# **Response to Request for Additional Information**

Sydney Metro City & Southwest

**Crows Nest Over Station Development –  
Modification Application (SSD 9579 MOD 1)**

| Date           | 15 September 2021   |   |

Figure 0-4 Lay-by Loading Zone in Clarke Lane for Site C waste collection, deliveries and loading

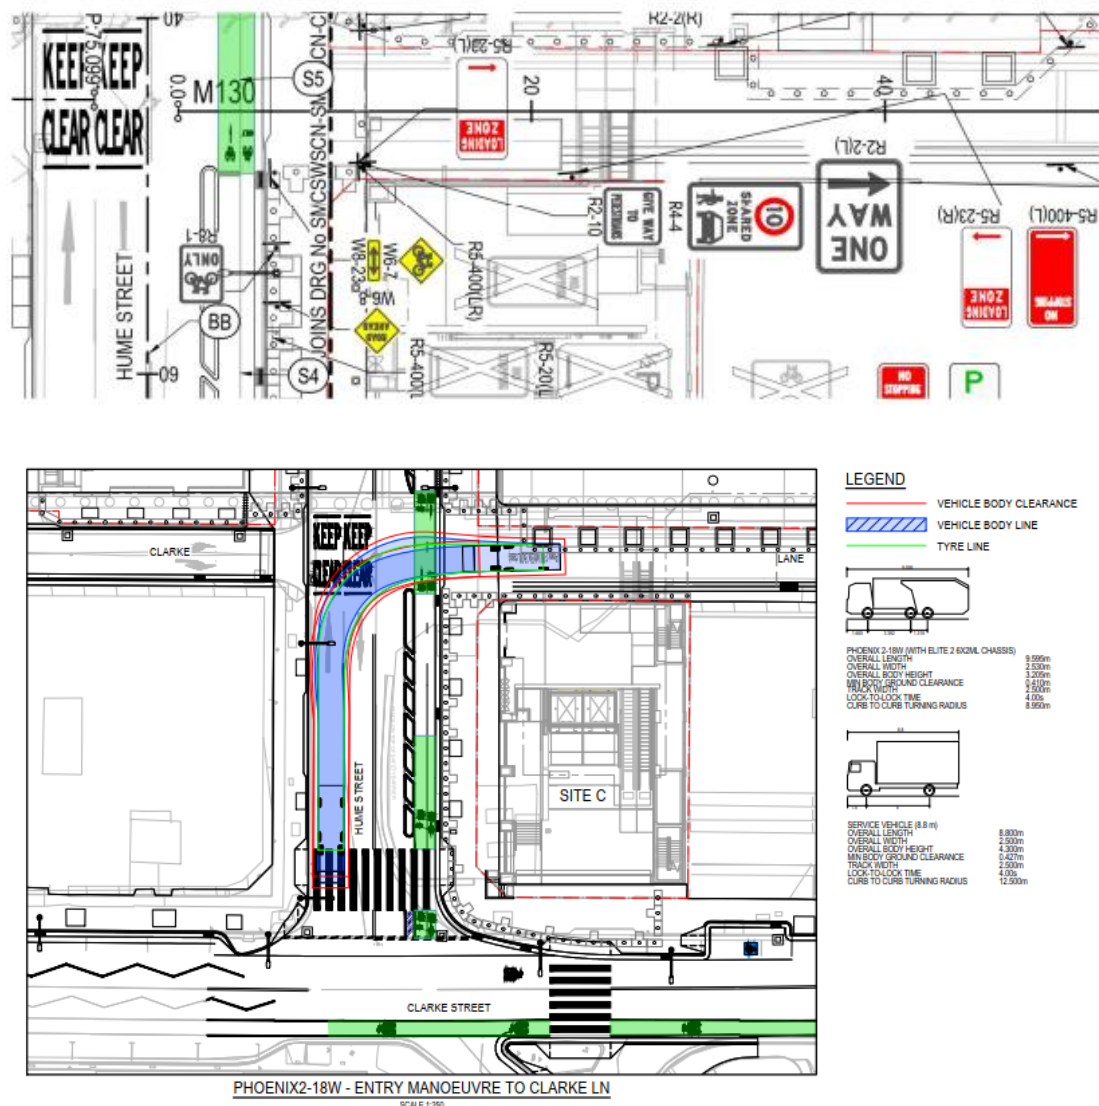
| Extract   | Response  |
|---|---|
| However, Council remains concerned regarding the safety and efficiency of maintaining the truck lay-over space in Clarke Lane, despite being included in the original approval. | <p>Noted. This arrangement was assessed in detail and found to be appropriate as part of the Concept SSD Approval. It is not a relevant consideration under this Modification Application.</p> <p>Nevertheless, we note that the safety and efficiency of the lay-by was extensively discussed in the Concept SSD Approval Traffic Statement dated November 2018. This included the preparation of detailed swept path assessments confirming no adverse operational impacts (refer to <b>Figure 1</b>)</p> <p>As identified in the Traffic and Transport Assessment Report for the Detailed SSD Application for the Site C OSD, deliveries will be encouraged during off-peak hours to minimise any interference with pedestrian and vehicle flows. This would likely avoid the need for delivery vehicles crossing of the footpath near a busy Metro rail station and is considered appropriate for the Site C OSD, which is a small commercial building.</p> |
